WELWYN HATFIELD COUNCIL  
PLANNING CONTROL COMMITTEE – 5 JUNE 2008  
REPORT OF THE CHIEF PLANNING AND ENVIRONMENTAL HEALTH OFFICER

S6/2008/0035/FP & S6/2008/0045/LB

ERECTION OF REPLACEMENT RESIDENTIAL ANNEXE ATTACHED TO LISTED WALL, REPLACEMENT OF EXISTING FLAT ROOF GARAGE WITH PITCHED ROOF. AMENDMENTS TO S6/2005/1561/FP & S6/2005/1562/LB

THE VINES, HIGH ROAD, ESSENDON, HATFIELD, AL9 6HS

Job No 528 Drawing No 02A

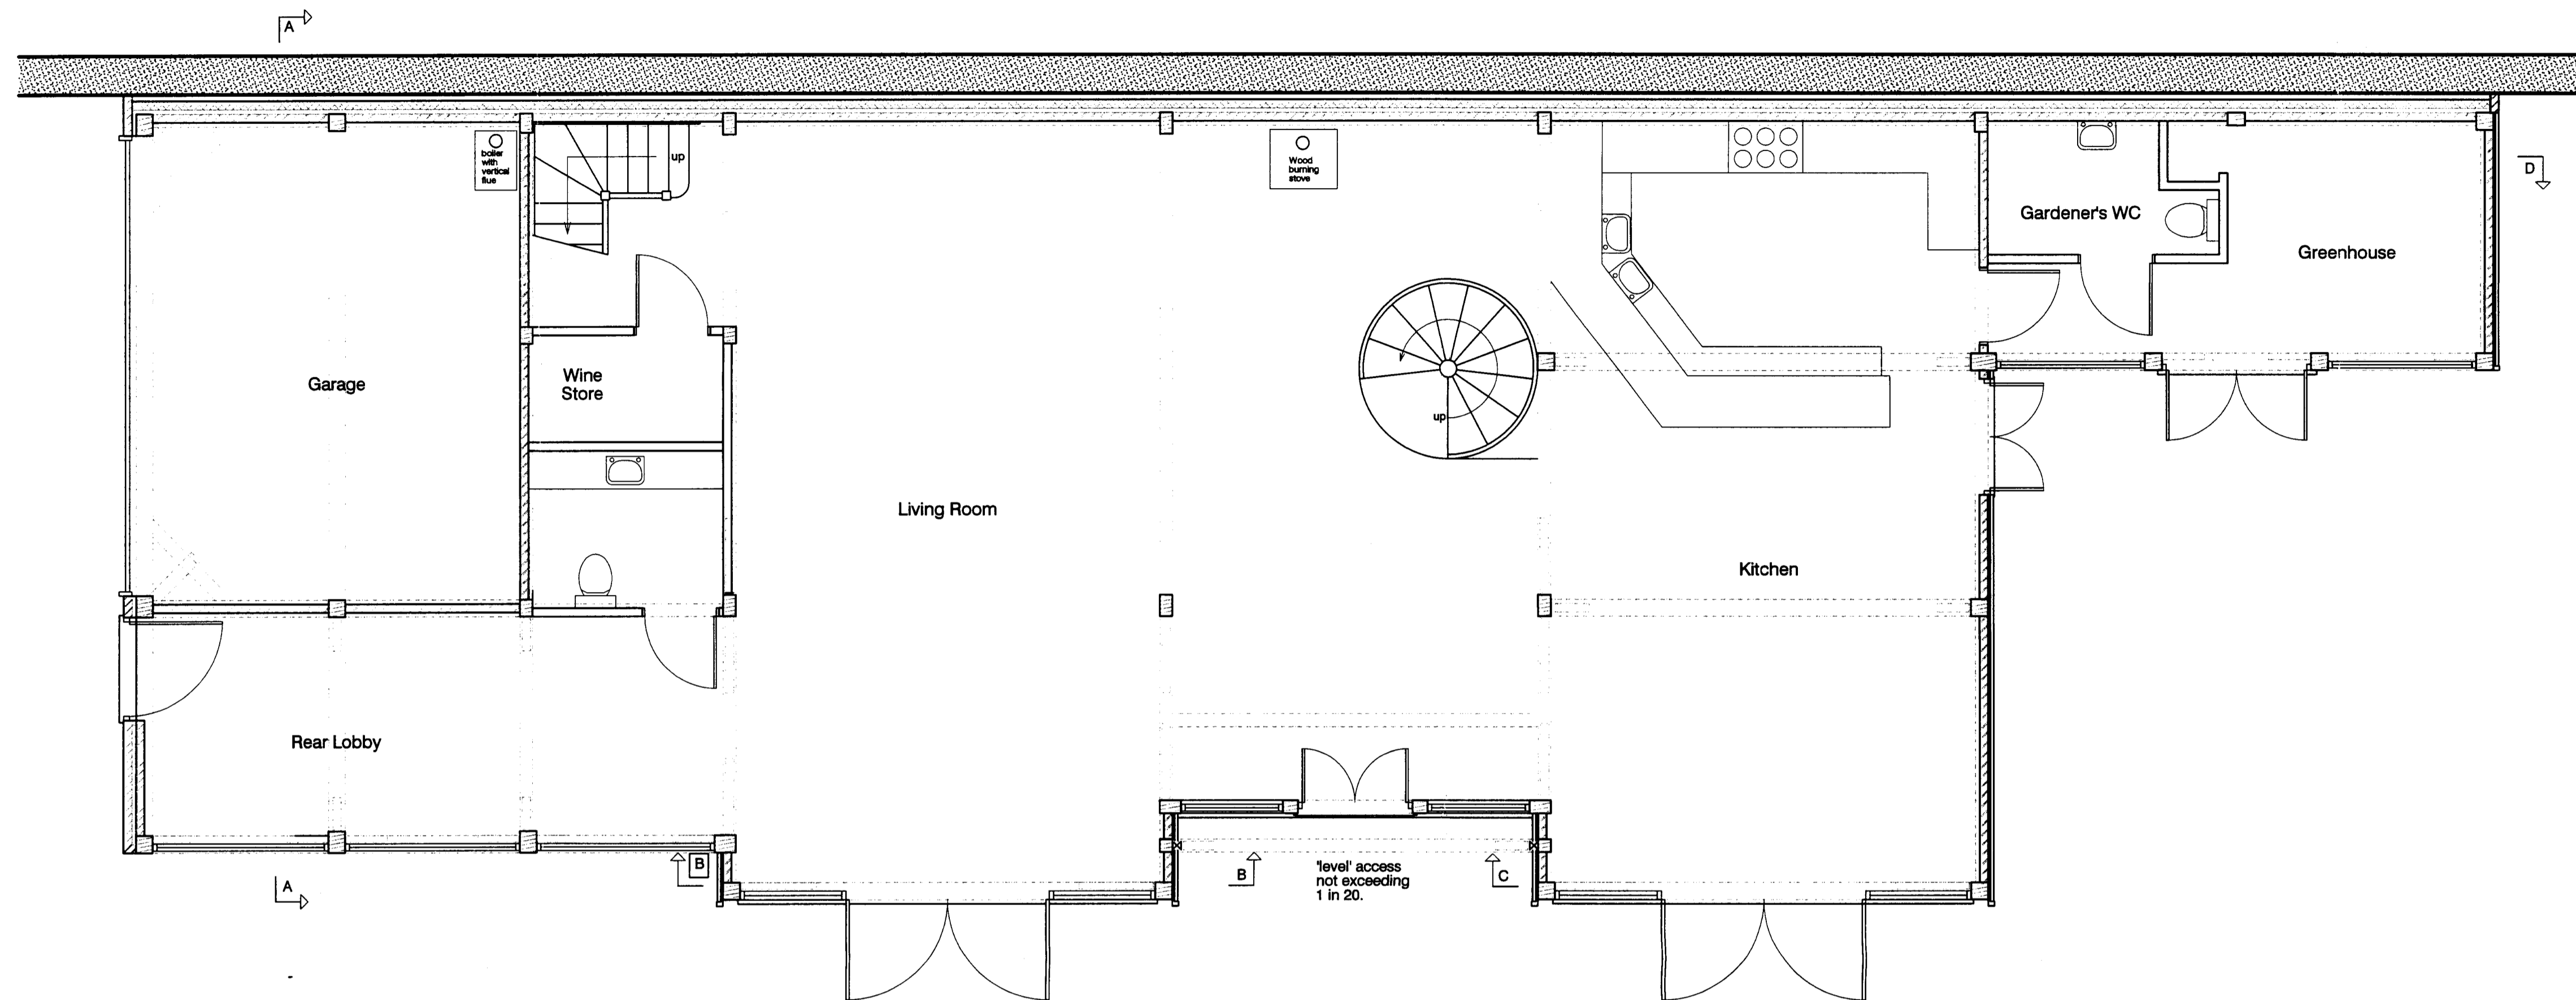
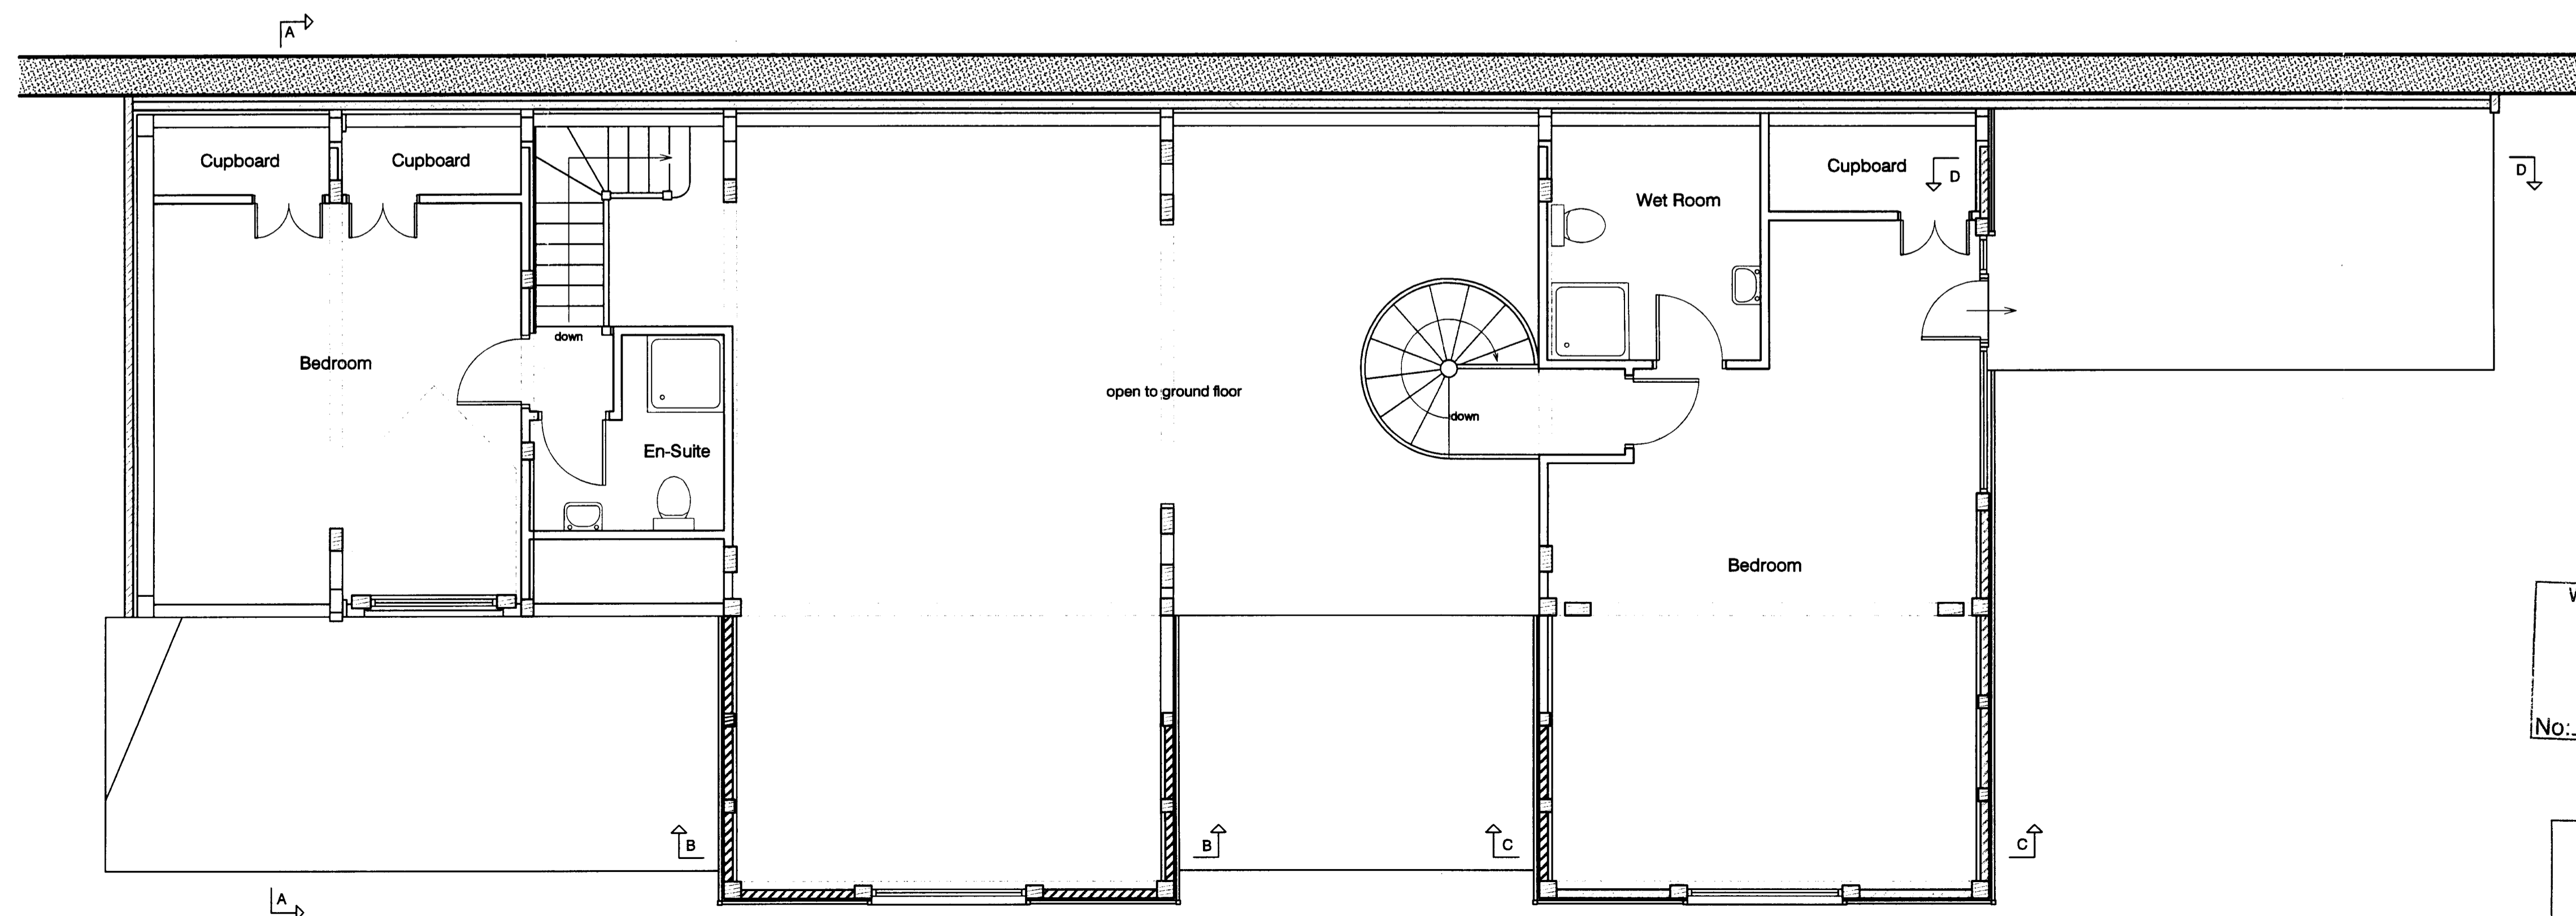
- The loggia and roof terrace to the western end of the building which was not originally approved and would result in overlooking to the adjoining dwelling.

- The increased size window to the first floor which acts as double doors onto the terrace reduces the privacy to the adjoining dwelling.
- The proposed chimneys are unsightly

- The annexe building is already extremely large and the changes are unnecessary for a building to be used in conjunction with the main dwelling
- The removal of the stairs and balustrade on the roof terrace needs to be subject to further control to avoid the flat roof becoming a terrace at a future date

- 9.14 There is also a requirement to consider the potential for overlooking to adjoining neighbours under this policy and guidance. Concerns have been raised by an adjoining neighbour about the potential for the loss of privacy from the flat roofed area over the greenhouse. This proposal has now been removed from the proposed scheme as no external staircase is shown on the design drawings or balustrade. Although no permitted development rights exist for this building, it would be reasonable to ensure that the functional use of this area does remain as a flat roof, as a roof terrace in this location would result in an unacceptable loss of privacy to the adjoining resident. A planning condition restricting the use of this area to solely a flat roof and not as a terrace, balcony or sitting area is suggested for any permission granted.

3. The flat roofed area over the ground floor area which is annotated as 'Greenhouse' and 'Gardeners WC' (on approved drawing 528/02A Received and dated 29/02/08) of the development hereby permitted shall not be used as a balcony, terrace or sitting out area.
